17 December 2020

COUNCIL SUBMISSION

SSD 10459 – CENTRAL SYDNEY INDUSTRIAL ESTATE AND DOWNER SUSTAINABLE ROAD PRODUCTS COMPLEX

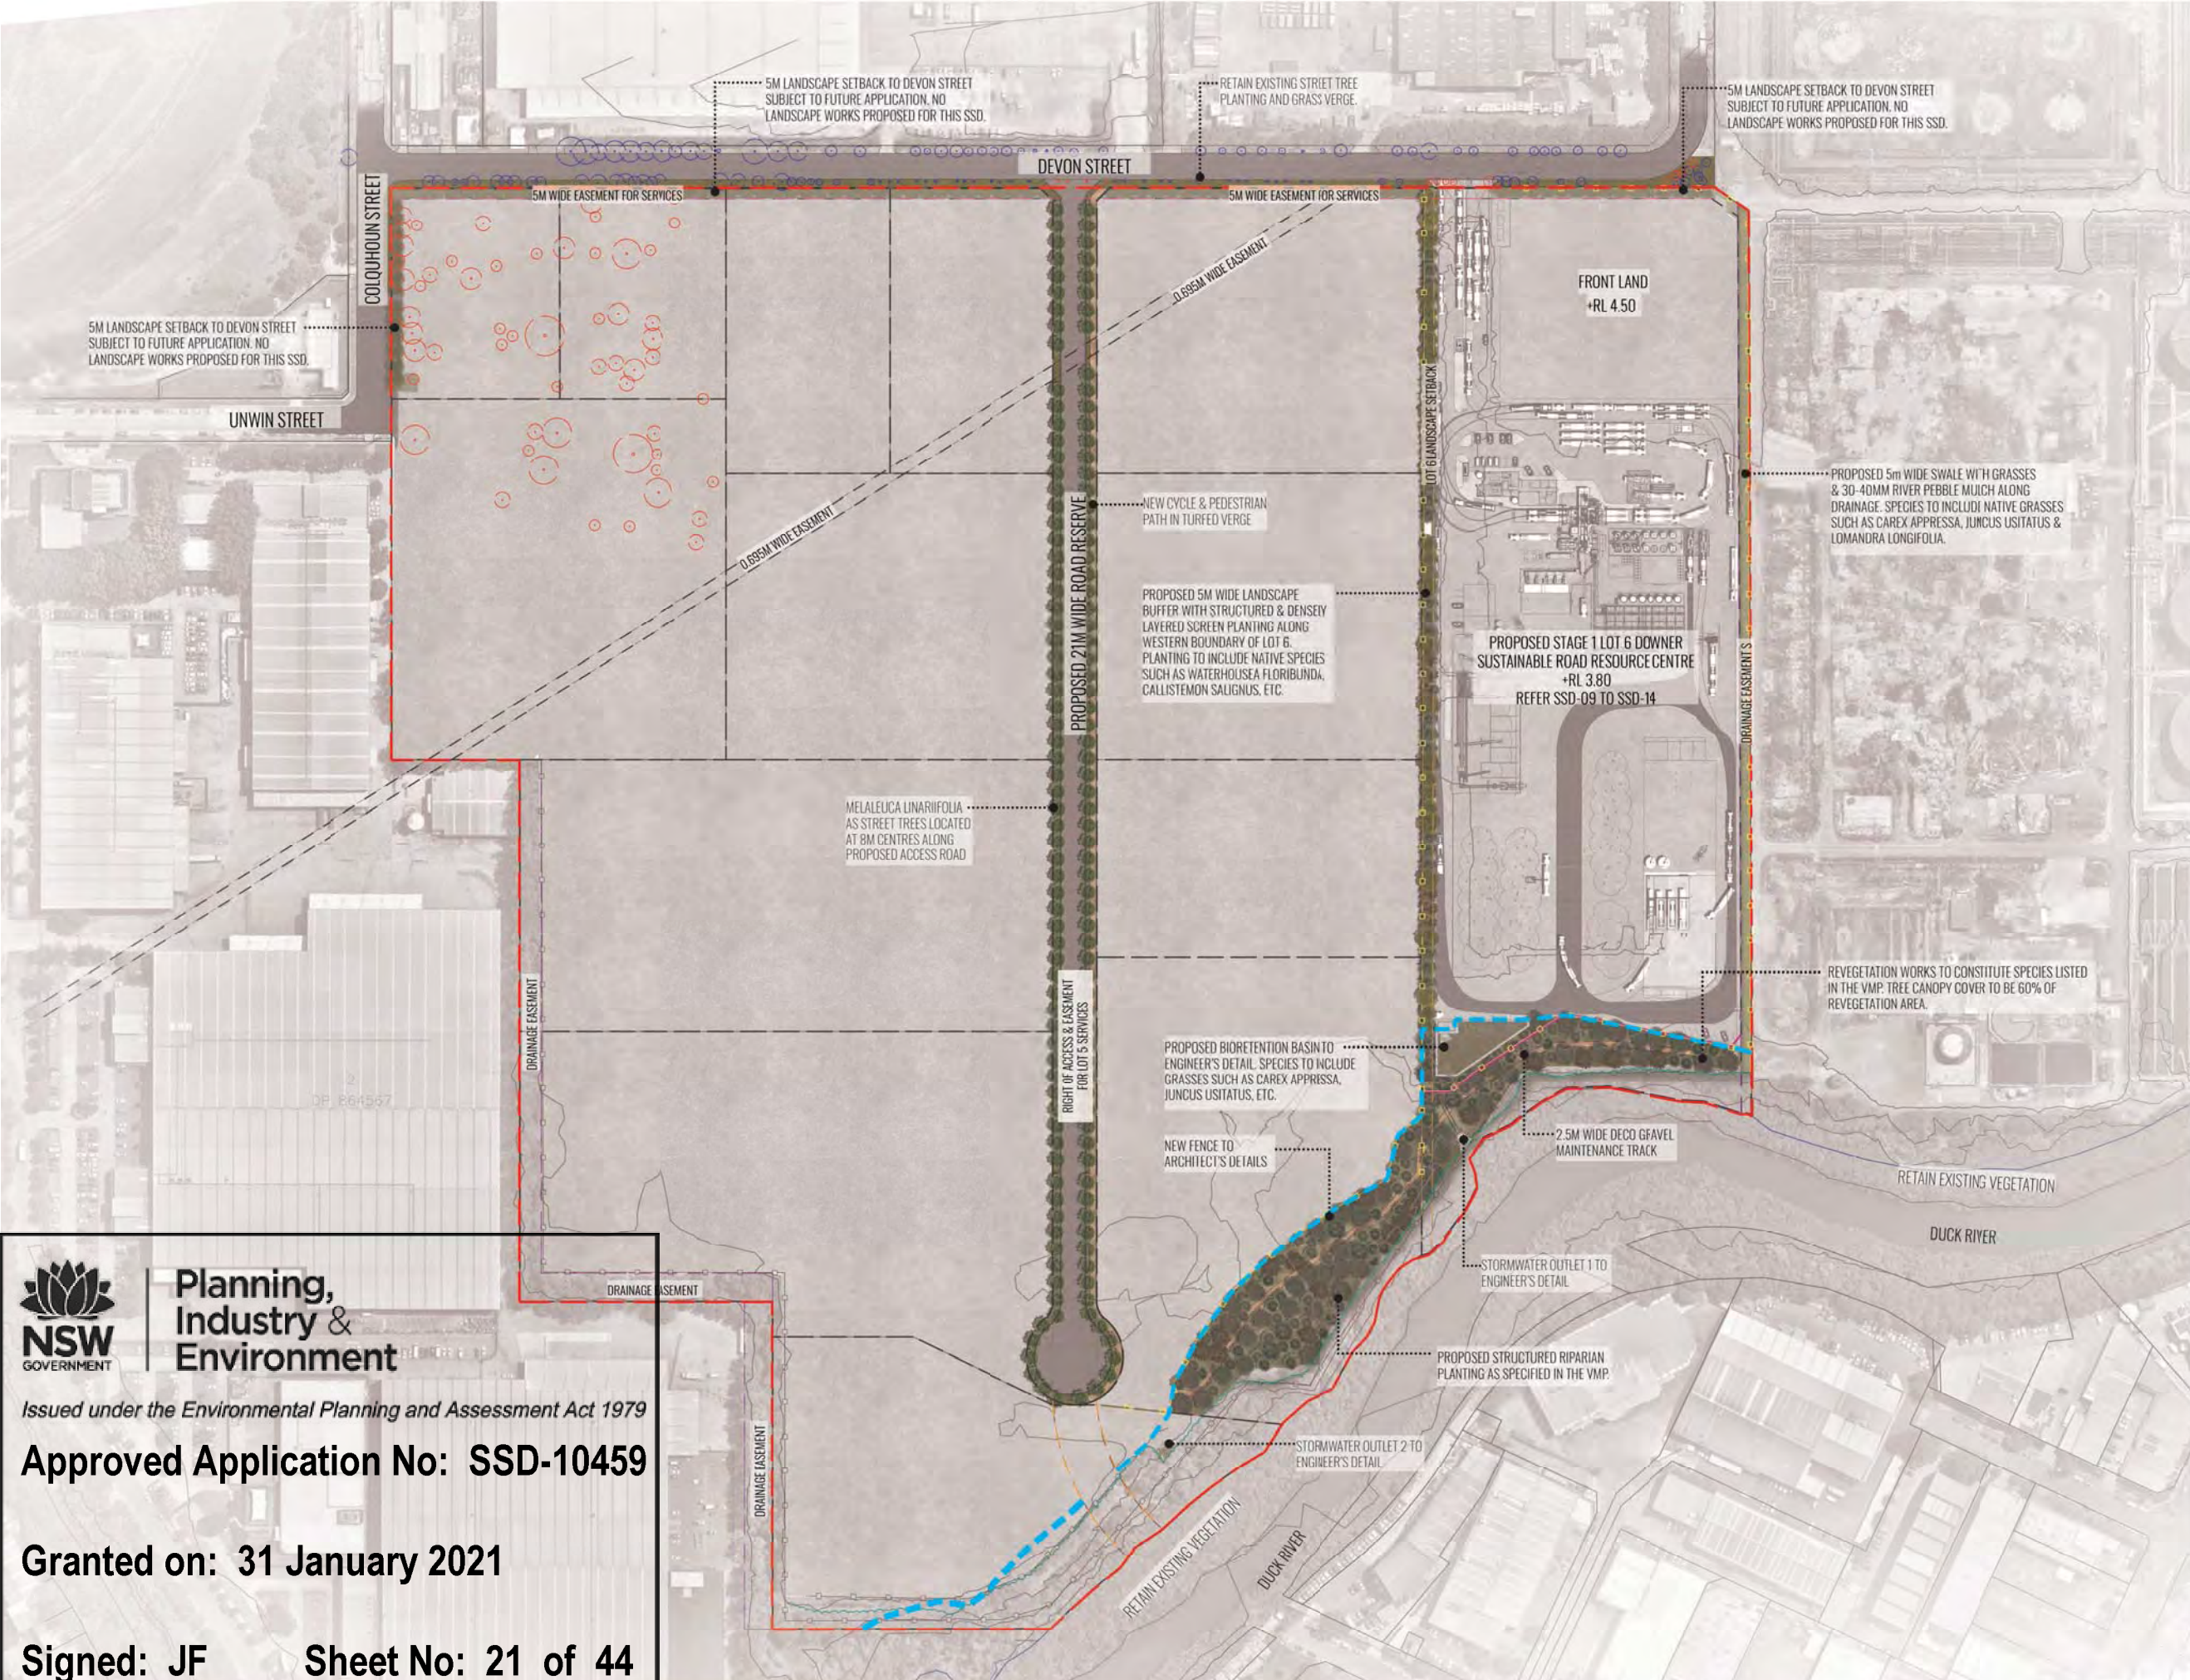
- There is a comment on drawing SSD-03 Rev K dated 26.11.2020 which mentions *the existing street trees may need to be removed at a future point and replaced with new street trees*. This is not supported and every effort should be sort to amend future designs and services to enable the retention of the high to medium value mature trees.
- It was previously recommended that the applicant appoint a Consulting Arborist to provide advice and guidance and protection measures for these street trees. This point still applies for any future design works and should be factored in at this stage. In this regard, council recommends the following:

The engagement of a AQF Level 5 Arborist ('Project Arborist') to provide a Tree Impact Assessment, Tree Protection Plan and Tree Management Specification to incorporate specific tree protection measures to the street trees located along Devon Street, in accordance with AS4970-2009 (Protection of Trees on Development Sites) and a Tree Removal Plan for any trees proposed to be removed.
